Portmarnock South Phase 1D

Stage 1 Road Safety Audit

| Document Title: | Stage 1 Road Safety Audit |

Drawing Title:  
 MOYNE ROAD JUNCTION LAYOUT

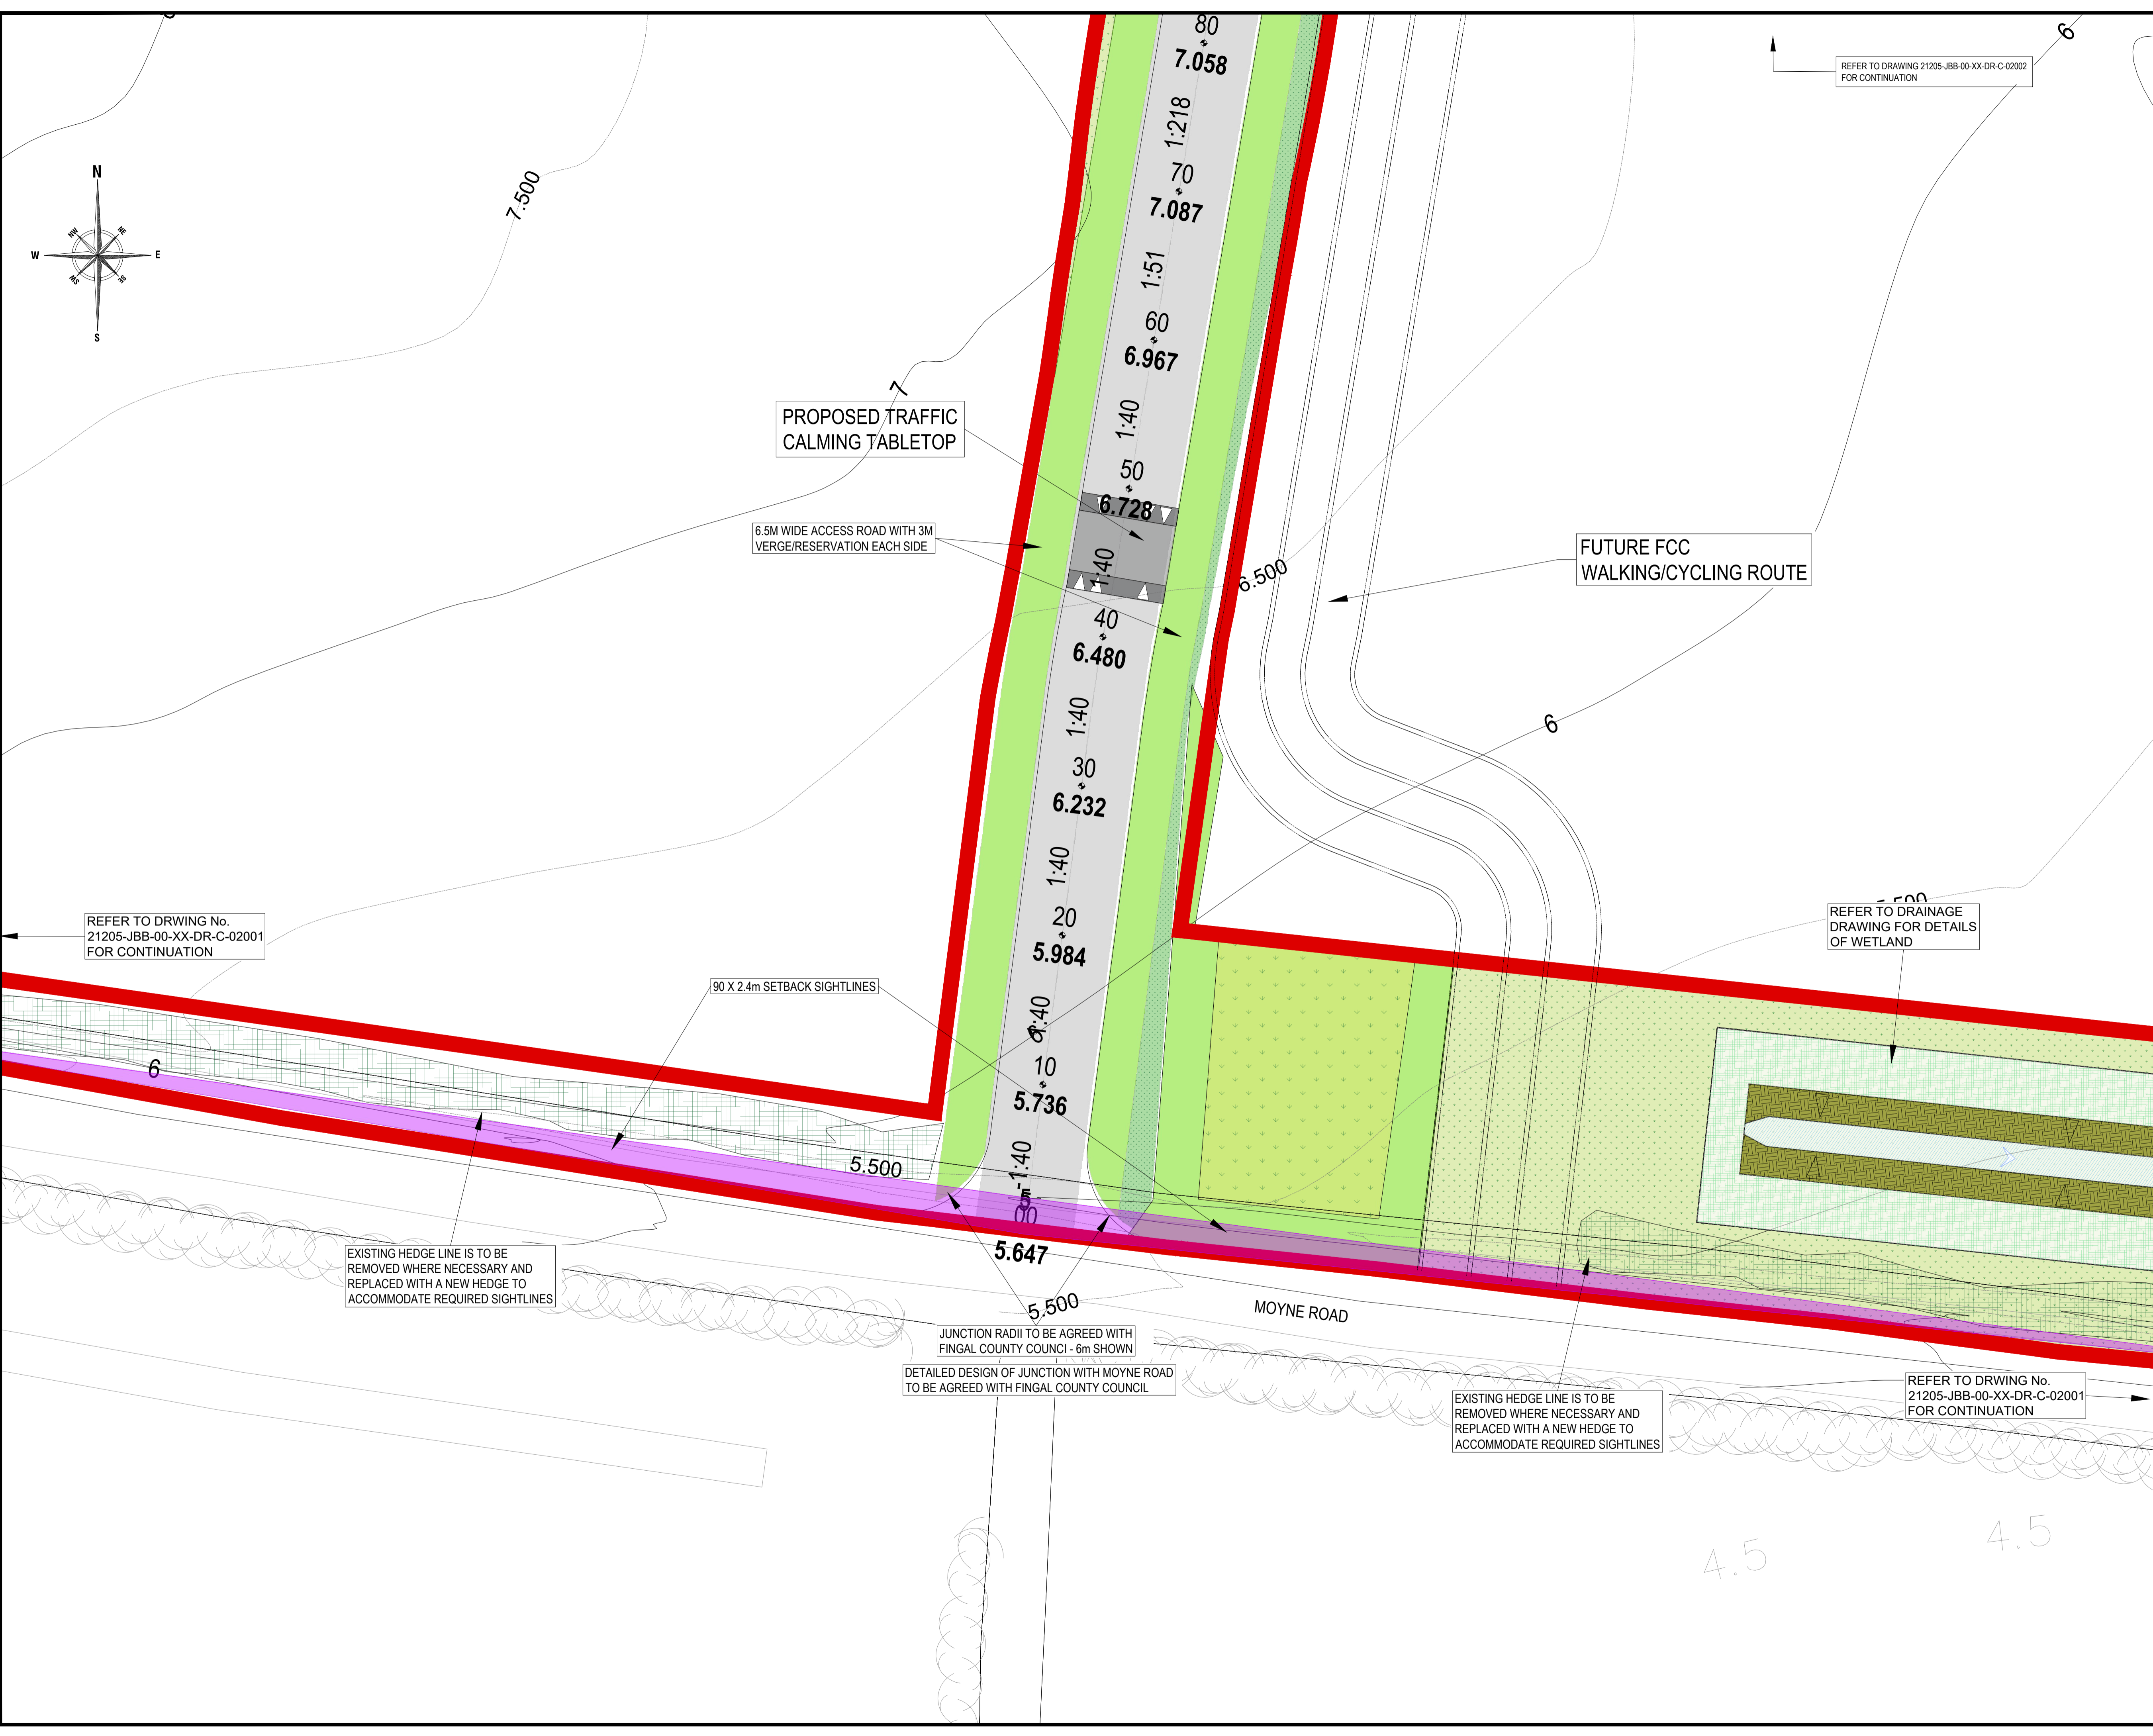
There is inadequate visibility in both directions where the proposed access road adjoins Moyne Road. Failure to provide adequate visibility to and from the junction could lead to angle, loss of control, and rear end collisions on the proposed junction.

Adequate visibility to and from the junction should be provided in both directions where the proposed access road adjoins Moyne Road.

| 2.16 | Yes | Yes | Adequate sight distances are being achieved by removing and re-planting hedgerow to provide 90m x 2.4m visibility splays for a junction onto a 60kph road. | Yes |
